5 October 2022

Re: Bowdens Silver Project (SSD 5765) – Traffic-related Request for Information

Figure 2.17
RELOCATED MALONEYS ROAD

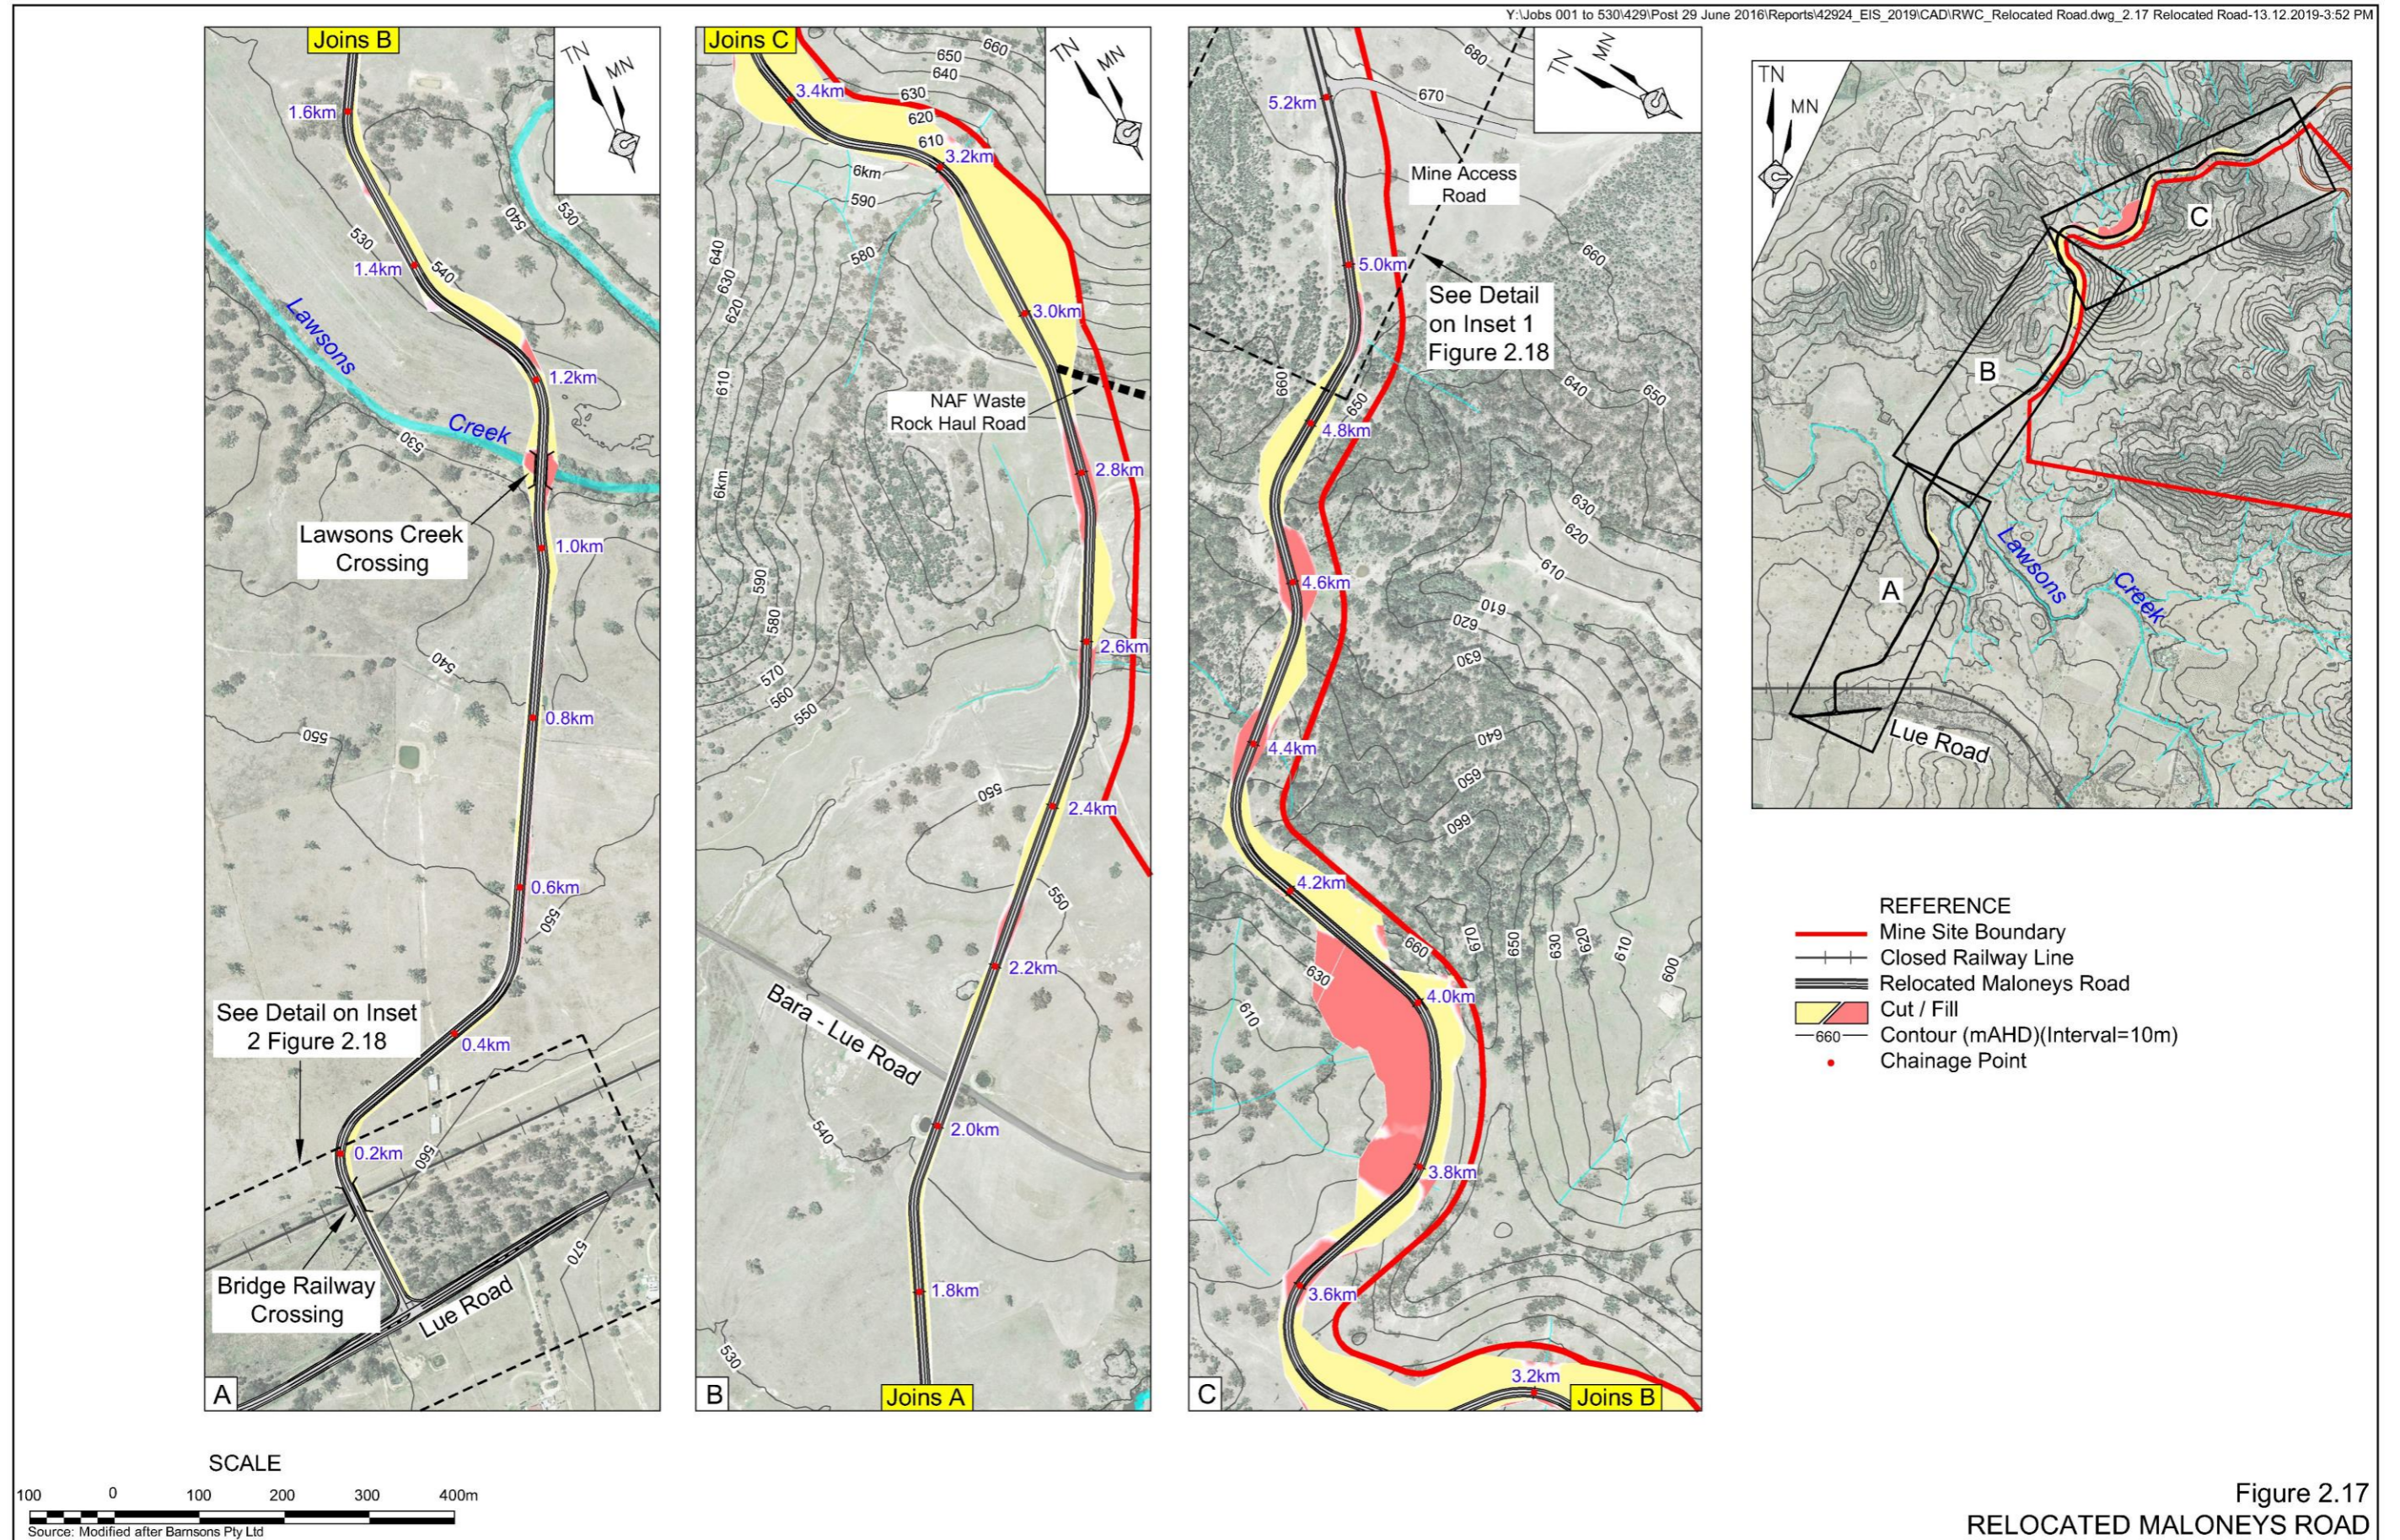
Heavy vehicle traffic along the relocated Maloneys Road, particularly the haulage route between the mine site access road and the TSF, would be significant at all times, but in particular during peak construction it appears that there would be an average of one project vehicle every 1 - 1.5 minutes, and when the TSF lifts are under construction there would be an average of around 1 vehicle every 2-3 minutes (based on an 11 hour day). This presents a potential safety risk to other road users.

Please provide consideration of the option of retaining the existing Maloneys Road as a public road and designating the relocated Maloneys Road as a private road., and/or consideration of using an alternative haulage route within the mine site (possibly directly over the area of the TSF) rather than using the relocated Maloneys Road.

Please also provide details on the progressive sealing proposed for the relocated Maloneys Road, noting the potential for dust generation and a consequent reduction in road safety while the road is not sealed.

While the change in traffic levels across the entire length of the relocated Maloneys Road may be considered significant when compared to the current use of Bara-Lue Road and the existing Maloneys Road, the total traffic generation is not significant and would be mitigated principally by constructing the road to suit the intended use. The traffic generation for haulage of NAF waste rock to be used in constructing the TSF represents a significant increase in traffic but would only occur along a 1.4km section of the relocated Maloneys Road.

Retaining public access to the existing Maloneys Road following construction of the relocated Maloneys Road would be problematic given the high-volume nature of internal mining traffic, the size of haulage vehicles and other mobile equipment and the presence of these slow moving, possibly laden vehicles. The length of road where interaction may occur is 1.4km in the currently proposed configuration and this would increase substantially if public traffic was to pass through the Mine Site. It is standard practice for mining vehicles to have UHF radios installed and use positive communication while moving around the site, which requires that vehicles hold at designated positions until positive communication is received from nearby vehicles and equipment confirming that the operator is aware of the approaching vehicle and able to maintain a safe separation distance. It would be virtually impossible to implement this safety measure for public vehicles. Retaining public access would also require that Mid-Western Regional Council ultimately retain responsibility for the maintenance of the existing Maloneys Road.

Using an alternative route to the TSF is considered impractical and an unreasonable alternative. The location of the relocated Maloneys Road has been selected to provide a reasonable grade and separation from other Mine and public structures. A road through the proposed TSF adjacent to Walkers Creek is the only feasible alternative option but would require vehicles to climb at significant grades to enter and exit the gully, generating additional noise and exhaust fumes. In addition, the alternative road would only be feasible until construction of the TSF commences. This is programmed for Month 6 with the bulk of material to be supplied from Month 7 for immediate use. An alternative approach would require storage of approximately 2 million tonnes of waste rock prior to closure of the road and commencement of TSF construction. Not only would this be practically difficult, but it would also add unreasonable cost and time delays to the construction process.

It is proposed to delay sealing of the relocated Maloneys Road along the 1.4km section between the Mine Site and the TSF until the initial transportation activities are completed. This would have the benefit of enhancing road compaction and is likely to improve its longevity. In summary the following schedule is relevant to the construction of the relocated Maloneys Road.

- Construction of the relocated Maloneys Road – Months 3 to 6.
- Transportation of materials and TSF construction (including the starter embankment) – Months 6 to 17.
- Sealing of the 1.4km section between the Mine Site and the TSF – Month 18.
